**REQUEST**

Current Zoning: R-3 (residential)  
Proposed Zoning: R-8 MF(CD) (multi-family residential, conditional)

Approximately 18.17 acres located along Plaza Road Extension, east of Faires Road and west of its intersection with Interstate 485.

The petition proposes to rezone and develop approximately 18 acres to construct a single-family attached (townhome) residential development with up to 78 units at a density of 4.29 dwelling units per acre (DUA).

RZ-1

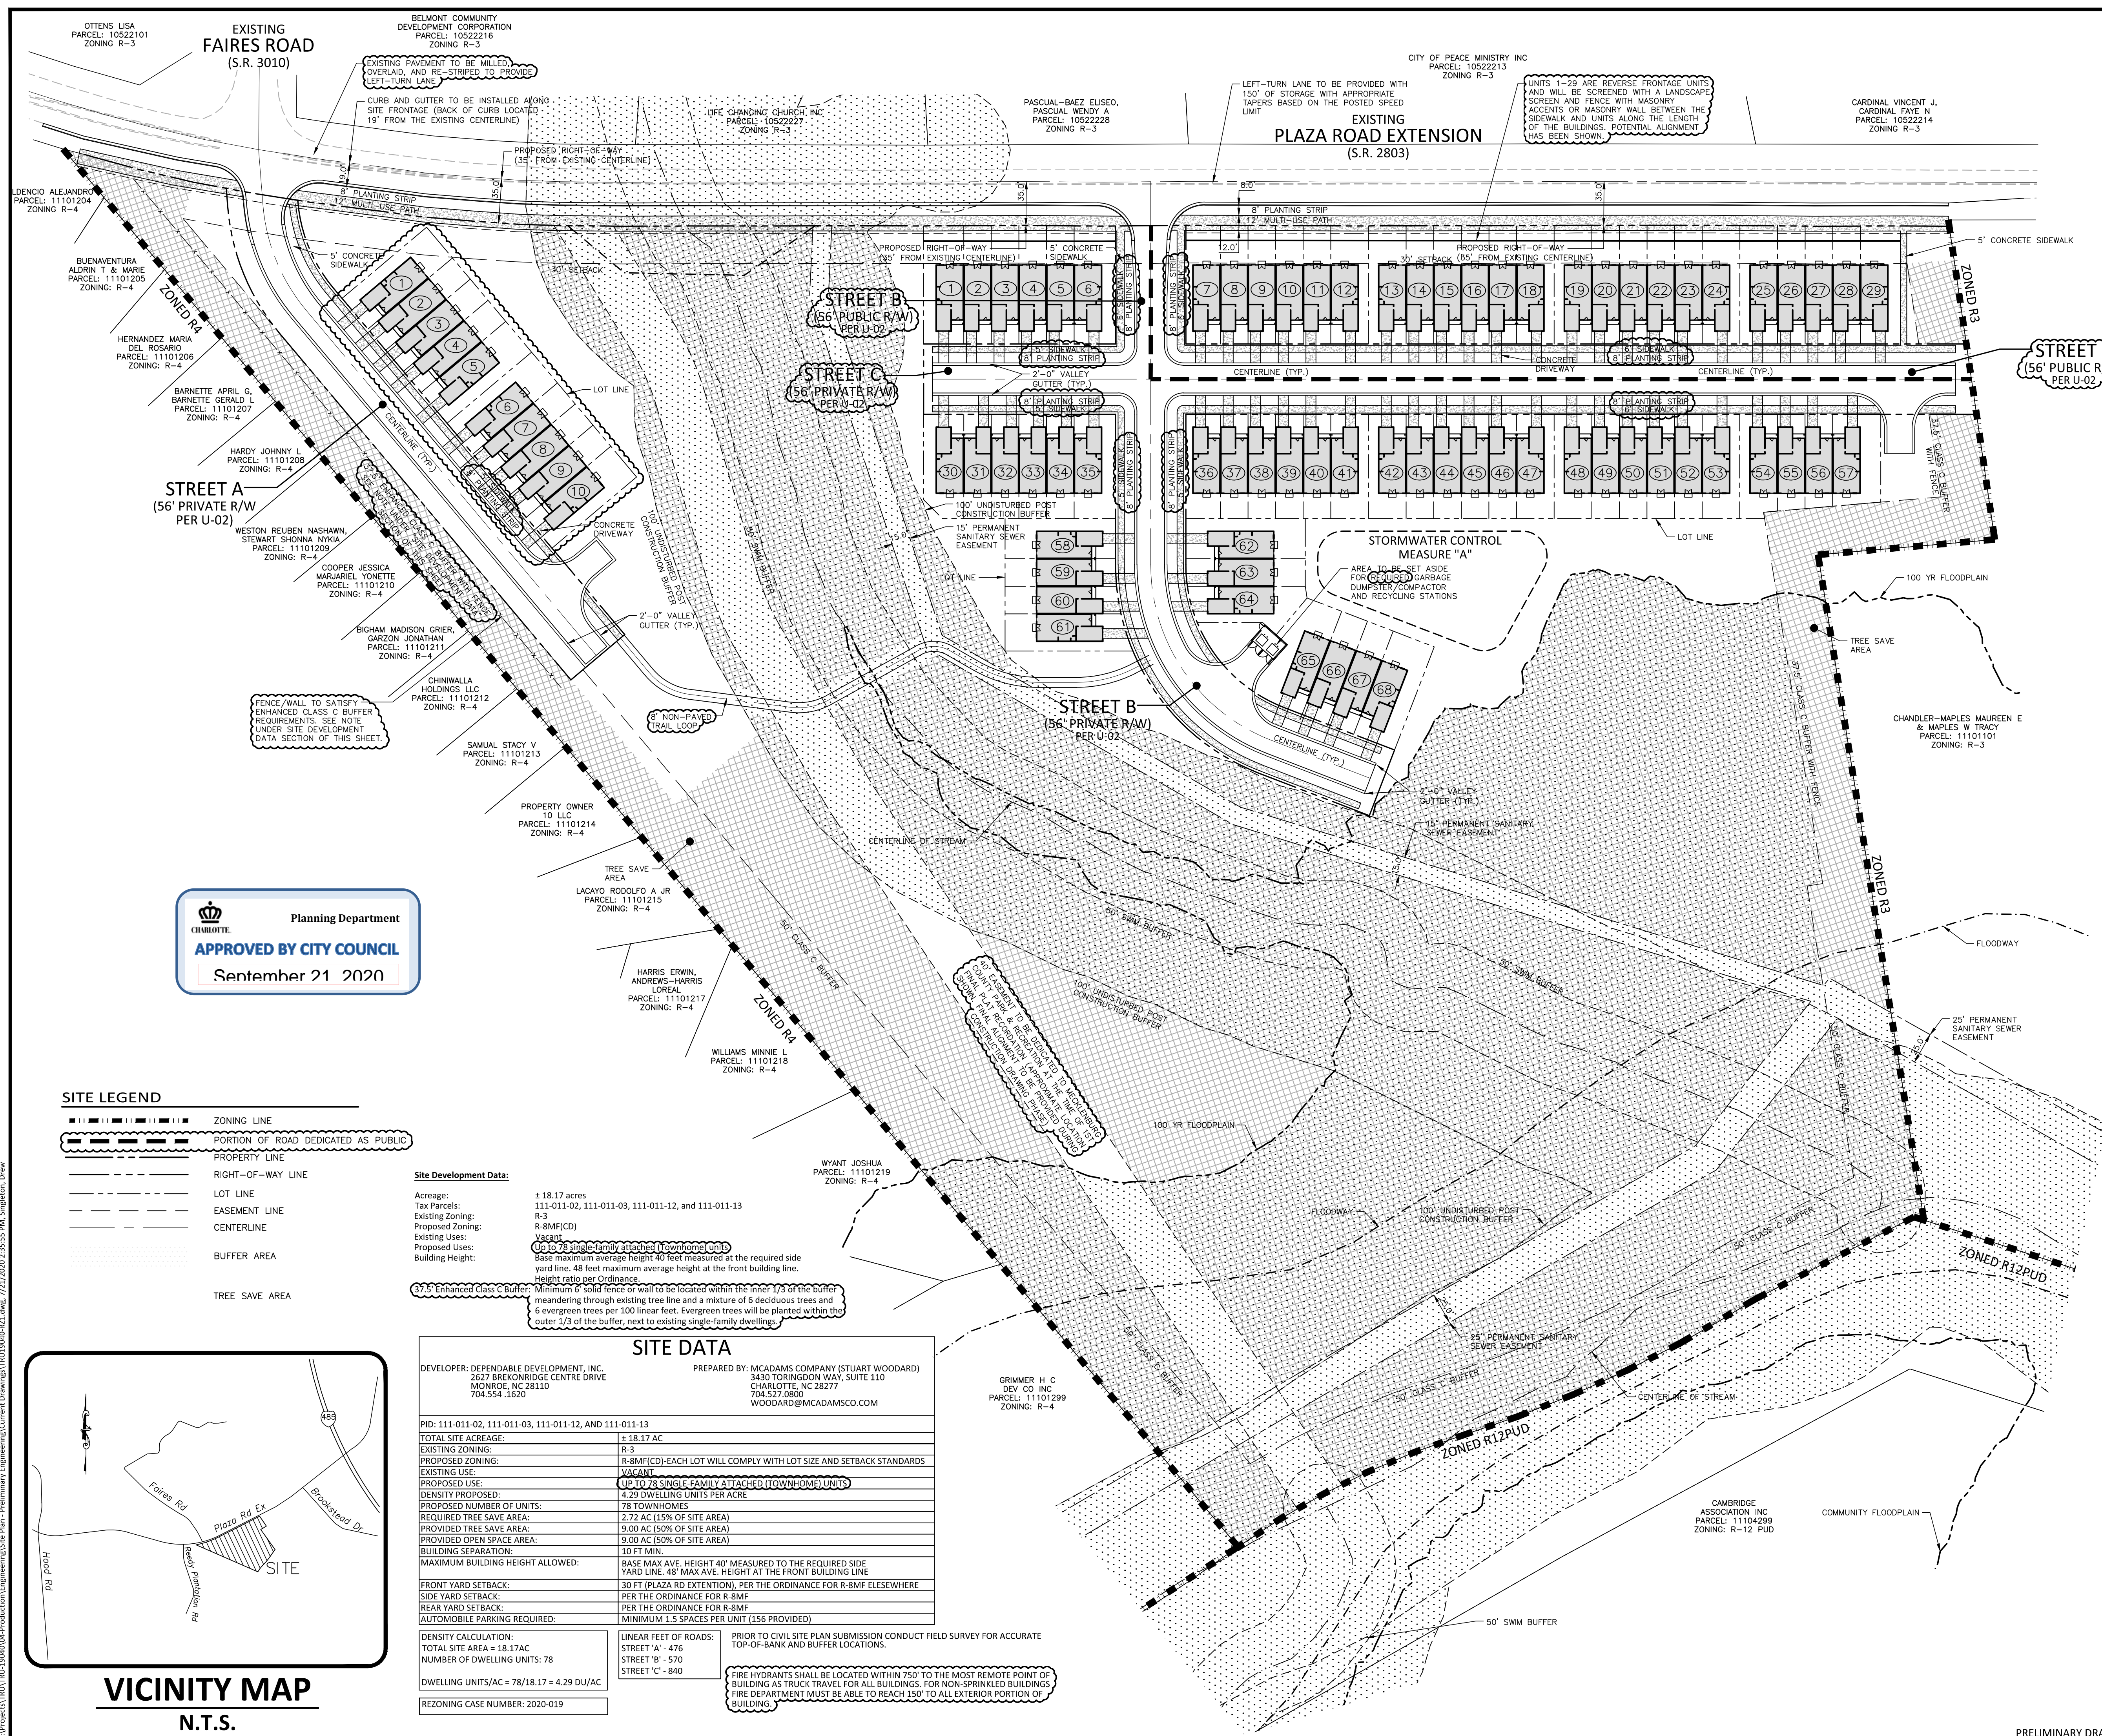
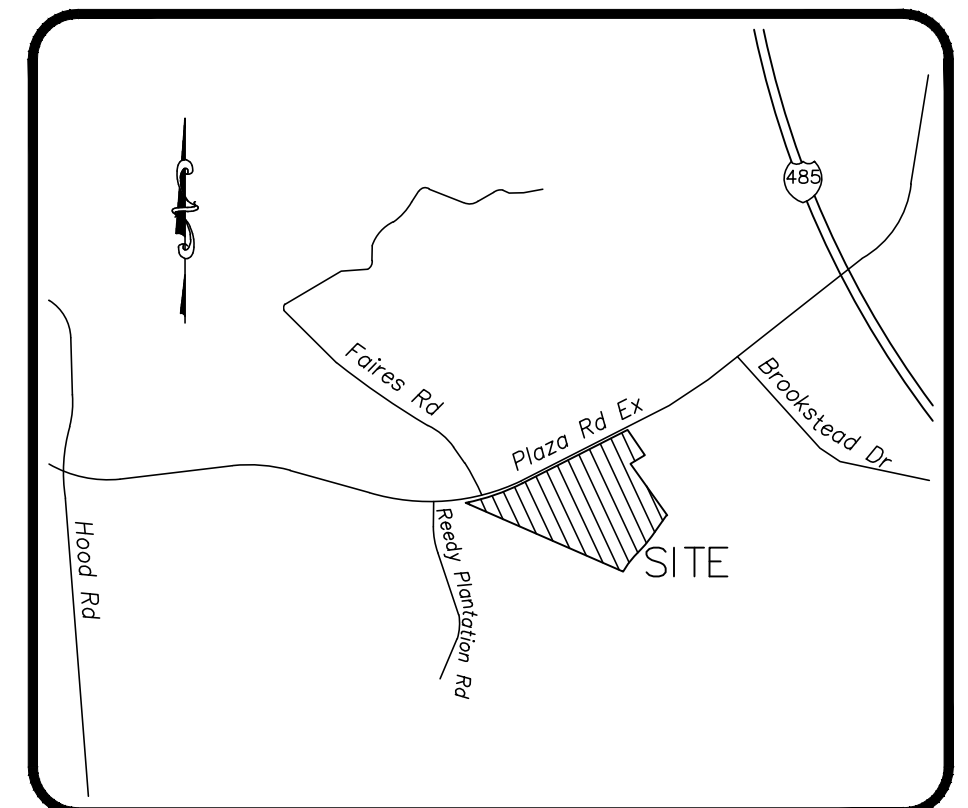
1. ~~Note 4.g. remove second sentence unless a clear commitment to not enclose those spaces is being made.~~ **ADDRESSED**
  2. ~~Note 5.a. should be removed unless there is a dedication of land or improved open space being proposed. If one of those scenarios exists, please describe the proposal in greater detail in the conditional notes.~~ **ADDRESSED**
  3. ~~Correct spelling of "units" in the development site data table on sheet 1.~~ **ADDRESSED**
-
